**Team Chris Subdivision, SF-24-26**

Please accept the following comments from El Paso County Public Health (EPCPH) regarding the project referenced above:

TEAM CHRIS SUBDIVISION

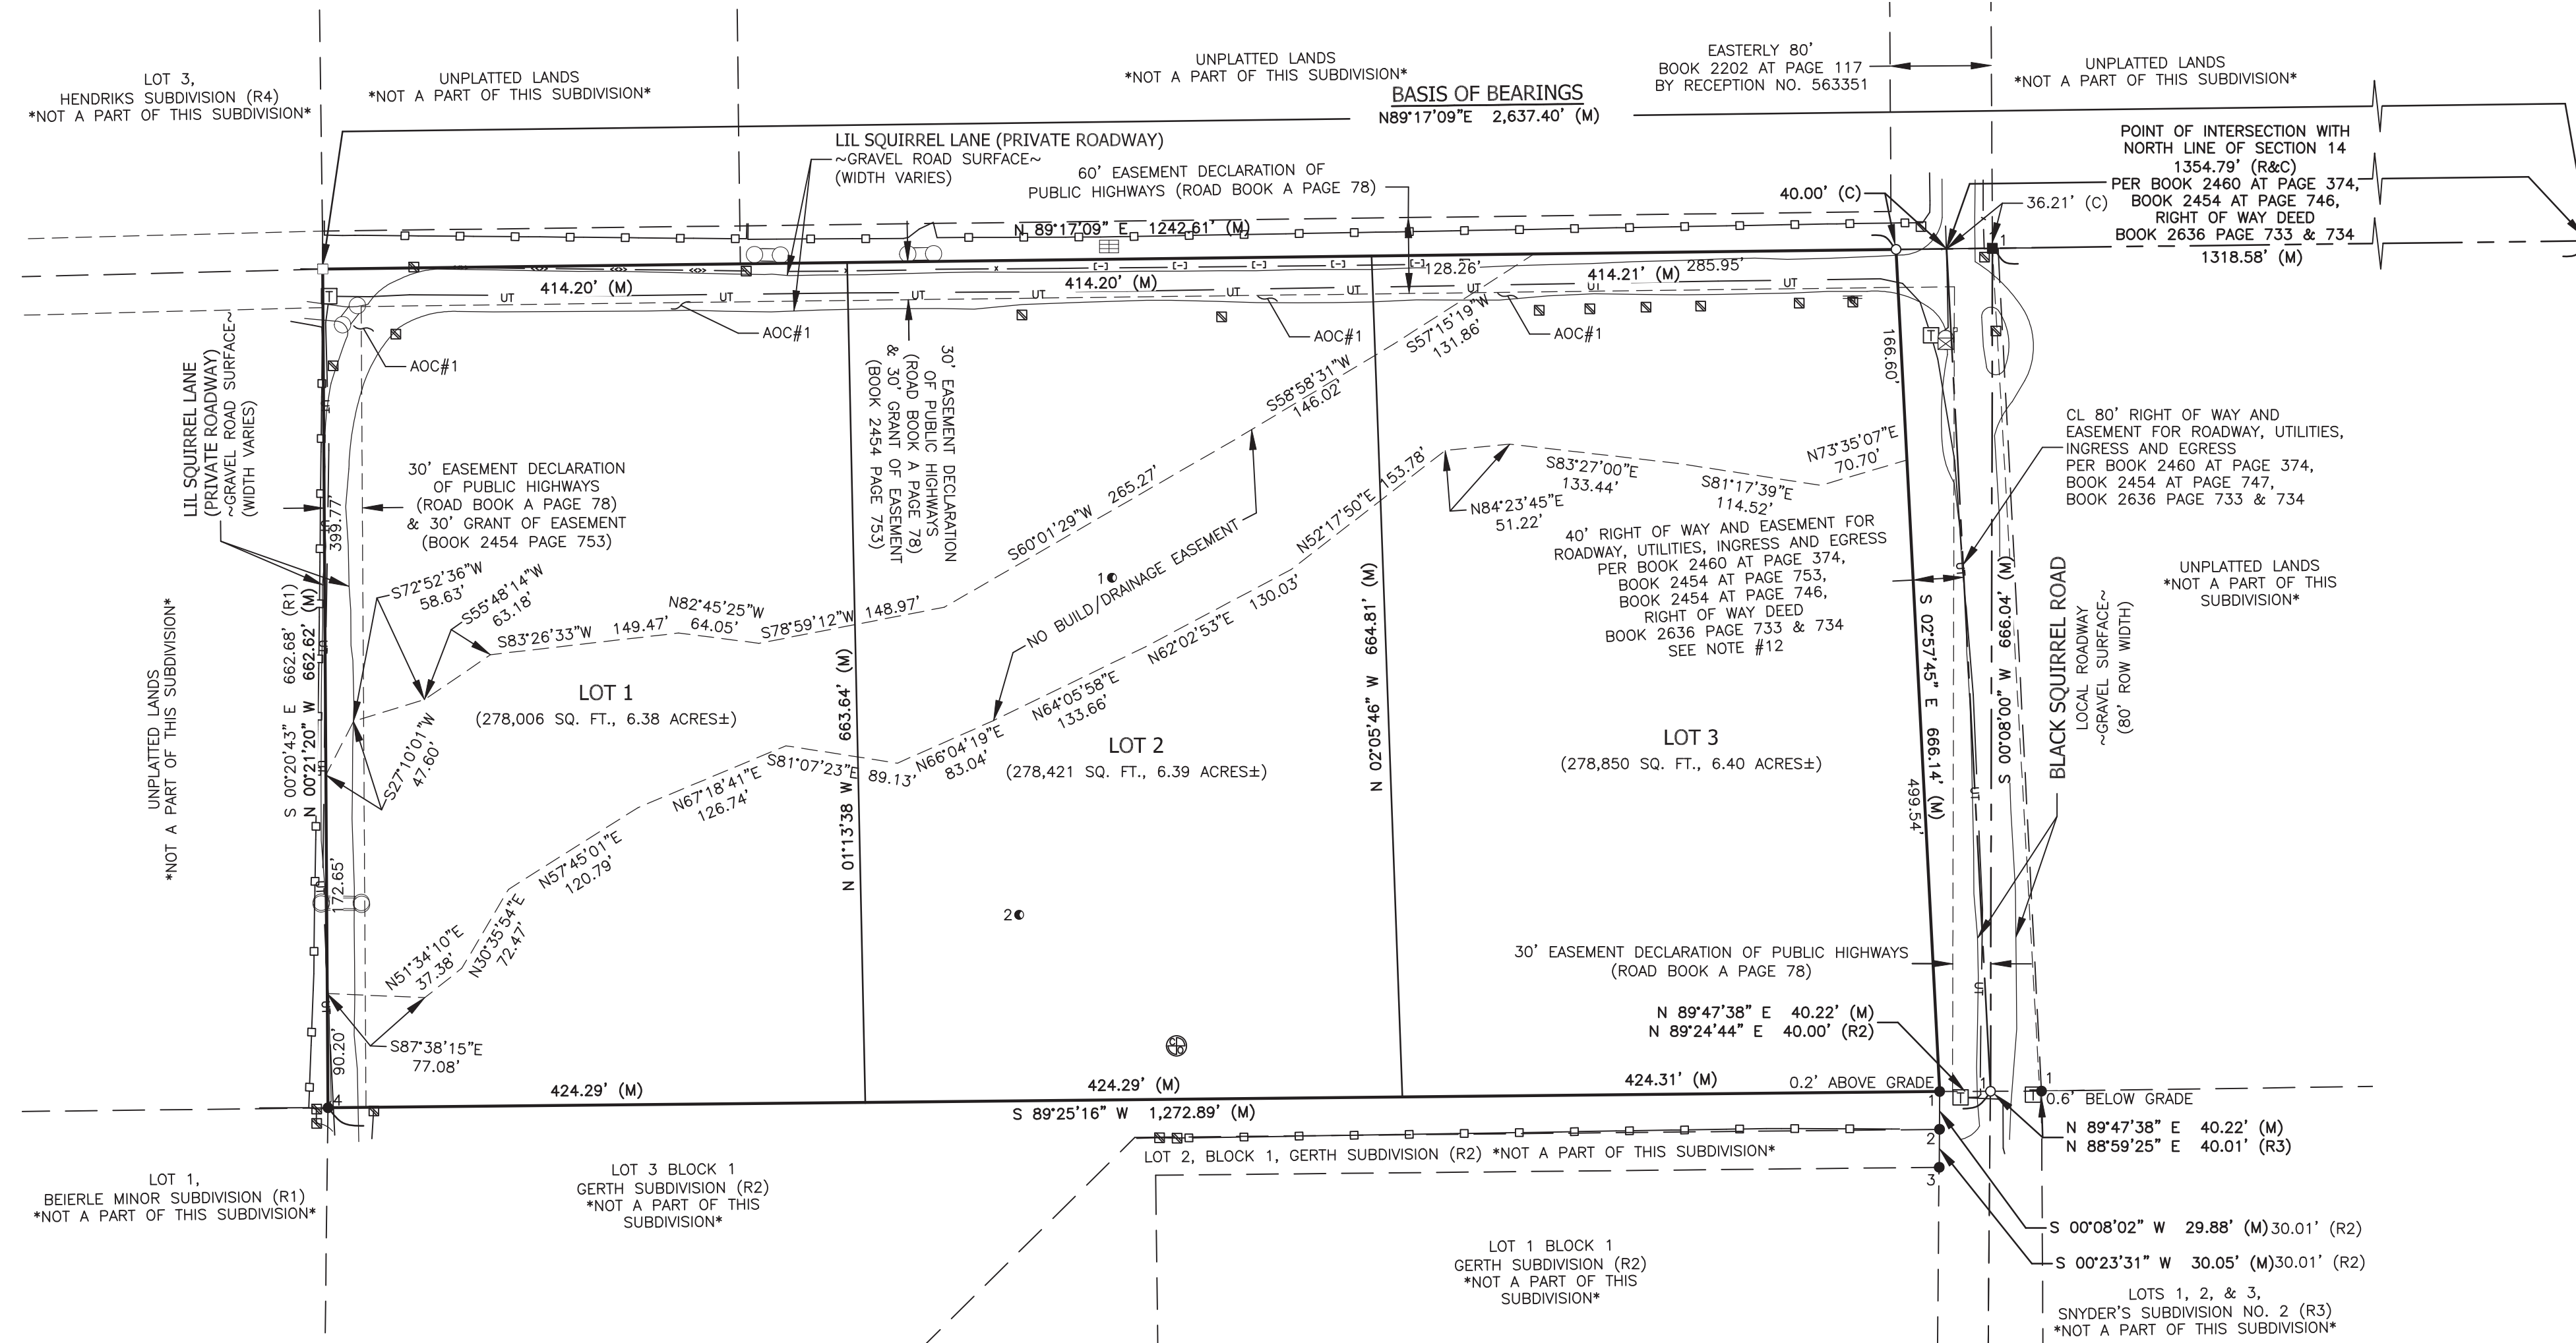
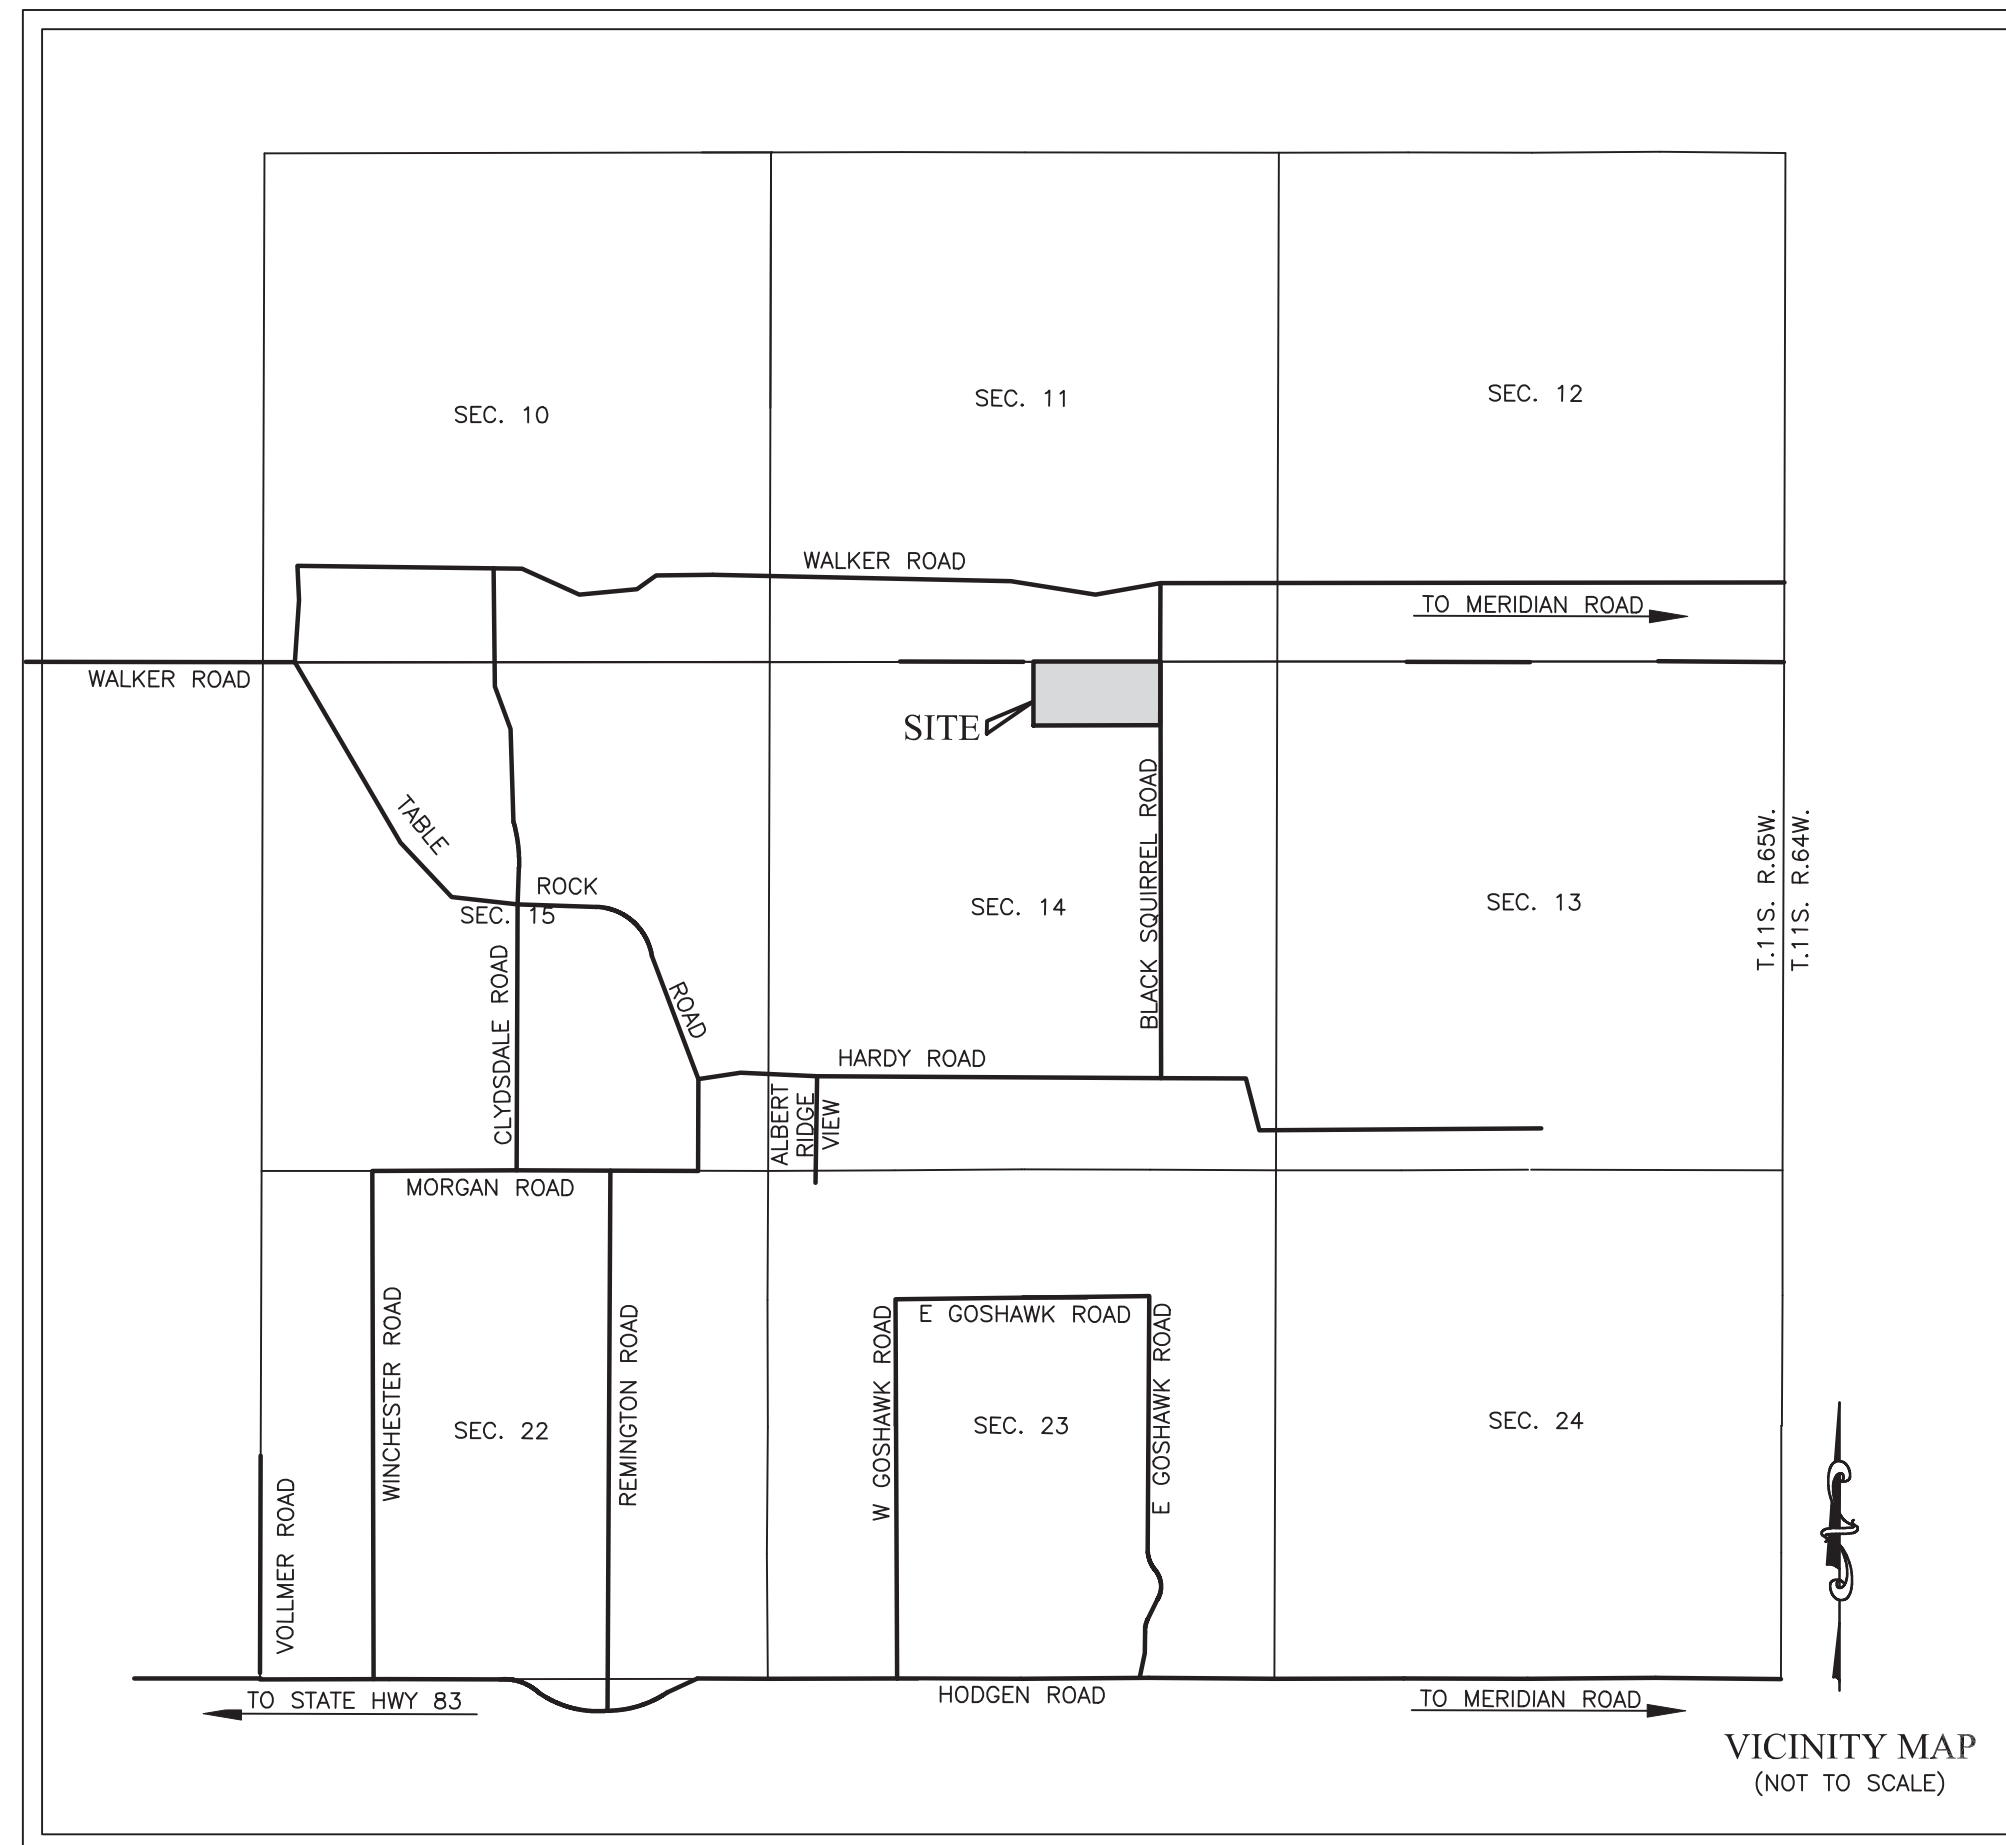
The drainage way that cuts through the development will play a major role in lot development. Plan carefully when locating the house, well, and the OWTS soil treatment areas.
